From: Michael Eastham
Sent: 05 July 2017 17:21
To: Planning.Responses
Subject: FW: Fitzalan Link - LU.234.16.RES

In summary, there appear to be just three outstanding points now – the choice of road surface, the requirement for a new or supplementary Stage 1 Road Safety Audit and the design of the shared footpath-cycleway connection to Highdown Drive close to the new Toucan crossing now proposed. The other points can be tied-into the detailed S38/S278 submission.

Subject: Fitzalan Link - LU.234.16.RES

| title  | PUBLIC RIGHT OF WAY DIVERSION PLAN |

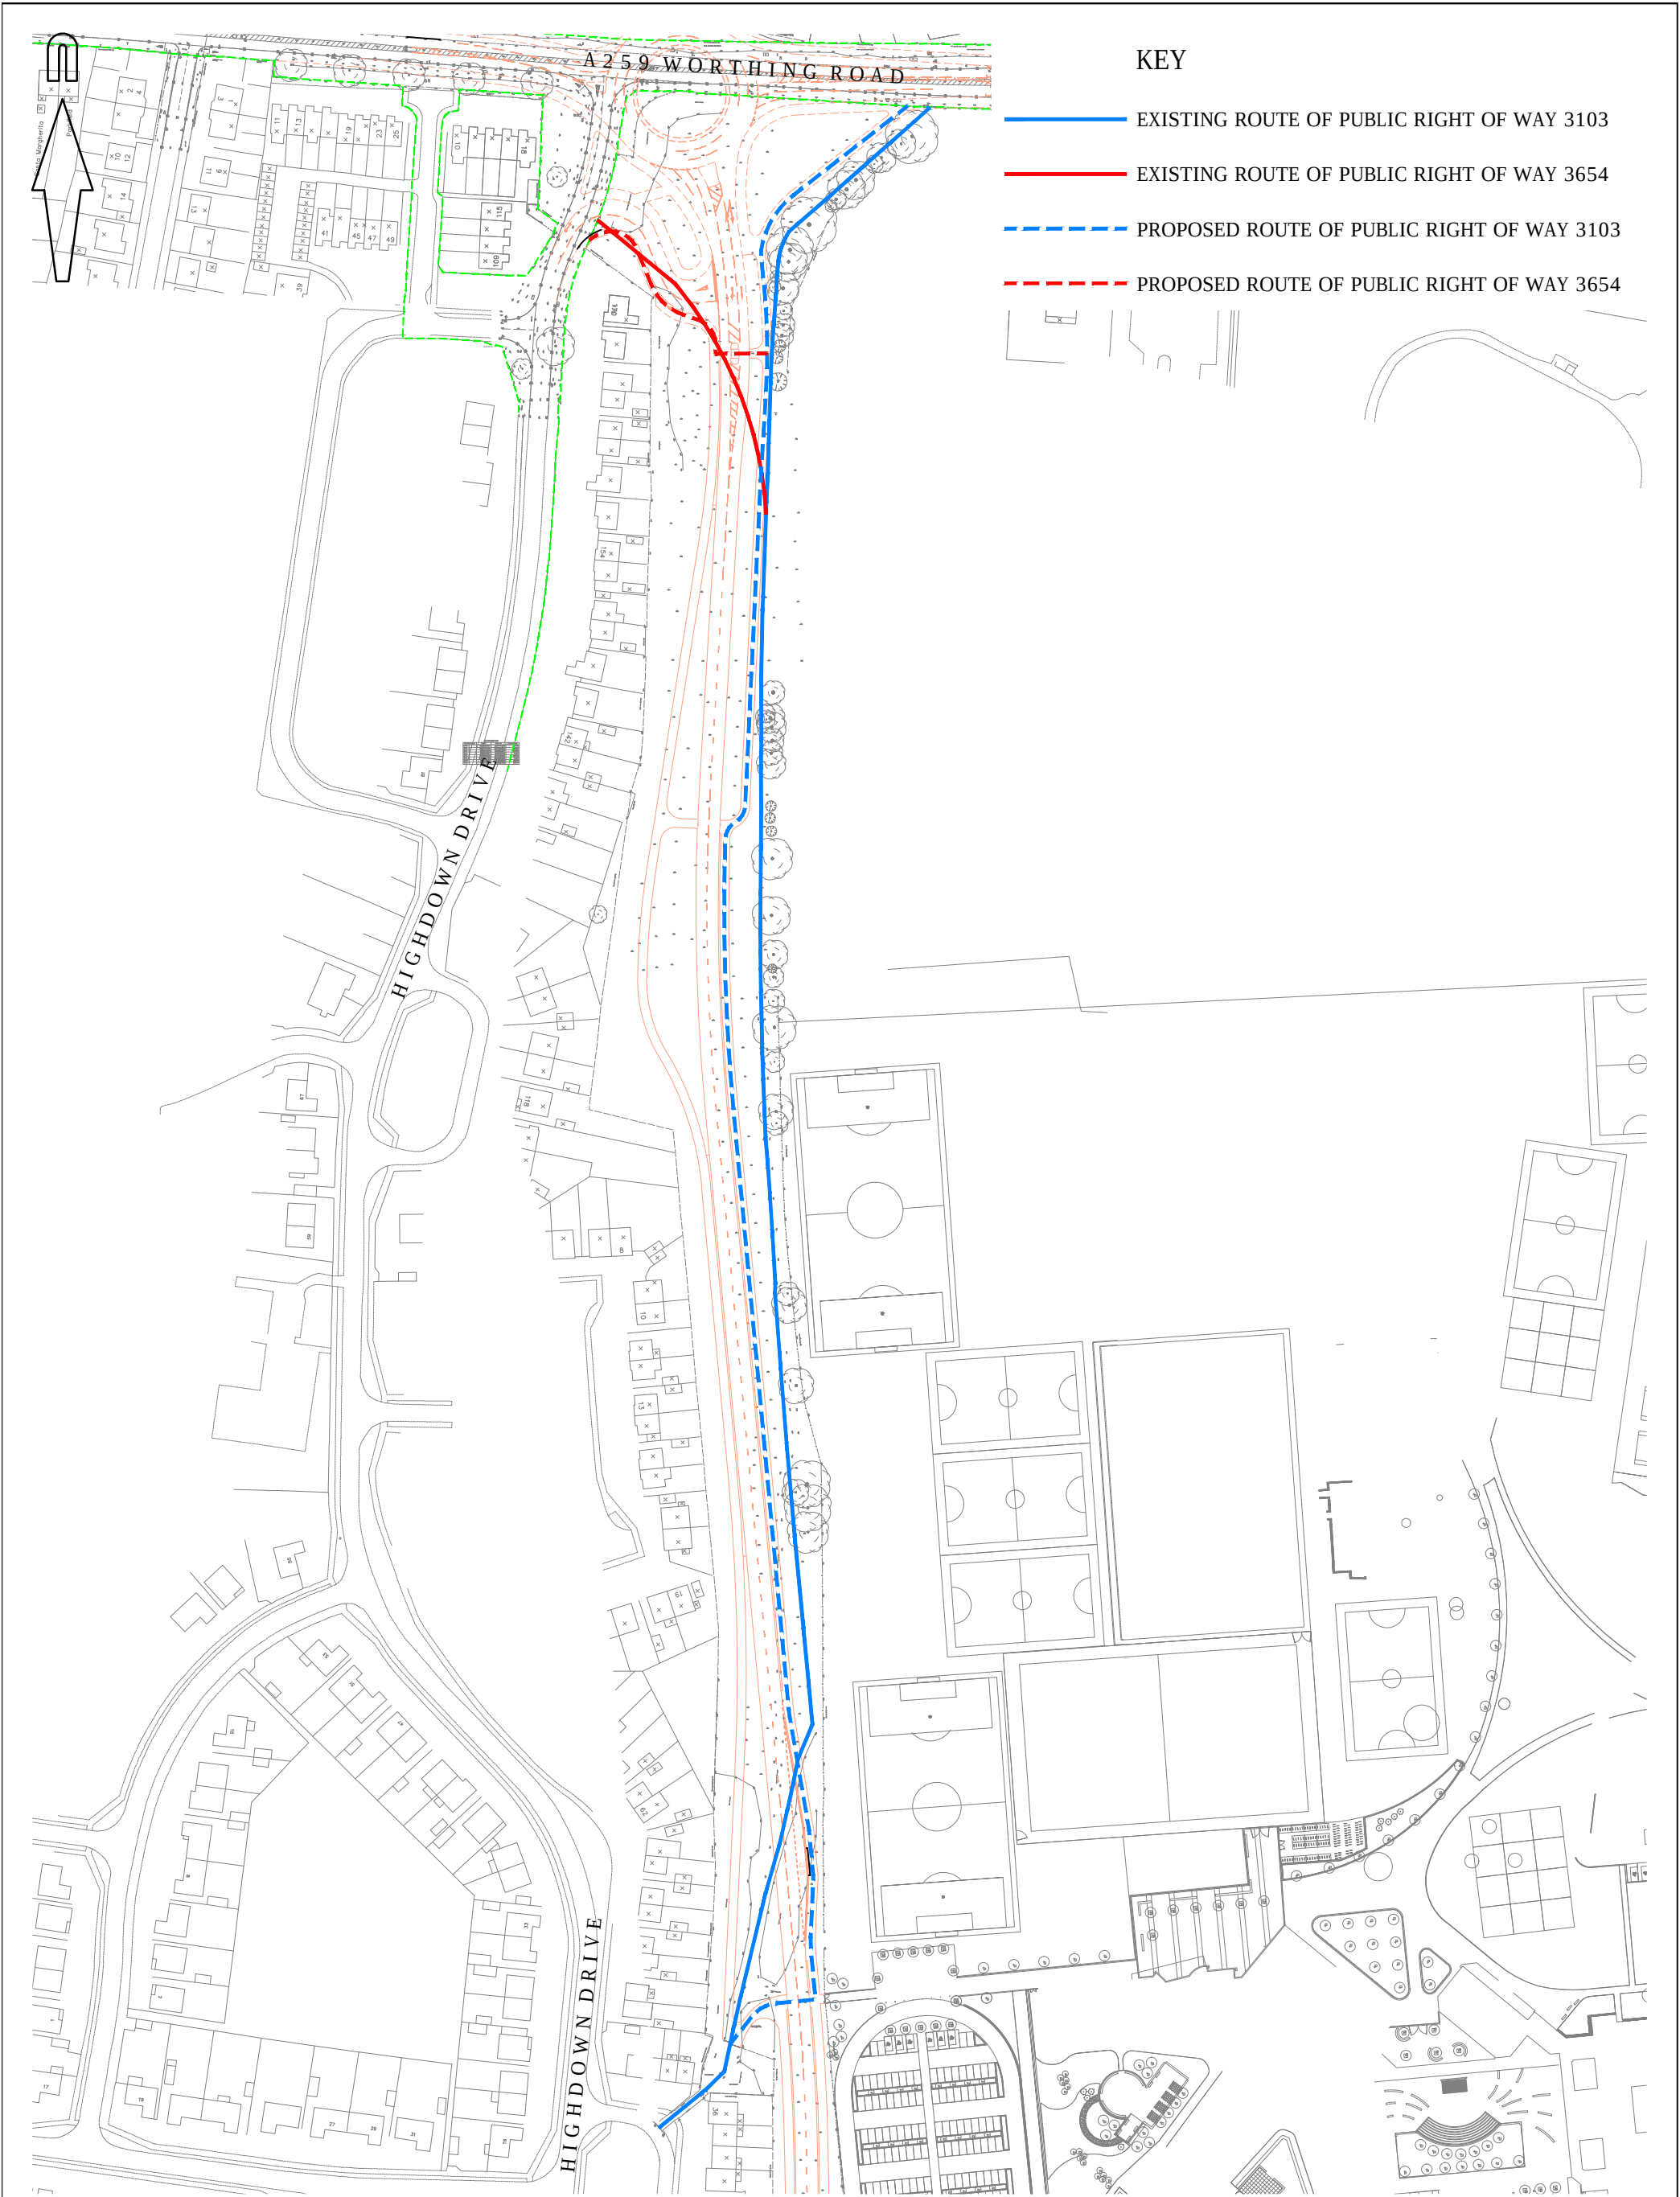
You have again offered an explanation for the path alignment in the vicinity of the Toucan crossing and balancing pond. The radii proposed are acceptable to us but the path must connect properly to the path leading to Highdown Drive which should be upgraded to a shared footway-cycleway. I have indicated below what this might look like. However, looking at this again shows the pink area to be public highway and on the line of part of Public Footpath 3103. Therefore, it is recommended (and indeed appears more straightforward) to retain this line otherwise it appears that any continuation of the route south of your scheme might cross land that might not be highway. Any path should be lit, edged, resurfaced, signed and tactile-paved appropriately although these final details can be shown at the S38/278 stage. Any upgrade from Public Footpath to shared footpath-cycleway must be undertaken in accordance with WSCC PROW procedures.

Any changes to formal PRoW (temporary and/or permanent) must only be undertaken following appropriate WSCC processes and/or procedures and obtaining all necessary permissions – some of which are often separate from any planning application processes. Full details can be obtained directly from the PRoW team here at WSCC.

The highway boundary plan and alignment of the existing PROW is noted. However, this is not evident on the ground since the Academy has been constructed (see extract from Google Earth below). We can show the alignment requested, (based on the OS Highway Boundary plans provided) but we would only have the power to construct the pathway up to our limit of ownership (the red line). WSCC has less than Freehold rights beyond the red dashed line and as such we don't believe we would have any power to undertake works on this area of land (see attached) to effect the PROW route beyond the red line, hence the reason for showing the tie-in (at the limit of ownership) to the existing physical route present on the ground. Therefore, we believe that what we have shown on the submitted drawings is the best solution, unless WSCC can confirm that we could legally obtain power to undertake works on land that they don't have complete freehold rights over. The legal line of the highway south of the Persimmon land is as shown in pink of the extract found below taken from my earlier email of 24th May 2017. As such, this is the line that should be used. As such, Persimmon should show their connection to the point shown on their boundary to ensure appropriate connection with the correct alignment. Persimmon to provide appropriate signage, lining, tactiles etc.

I have already sent a note on this. We will be submitting the diversion request under the TCPA to ADC. Once plans for the Fitzalan Link have been confirmed / approved I will start this process with relevant personnel at ADC. It is not a matter for WSCC. Noted.
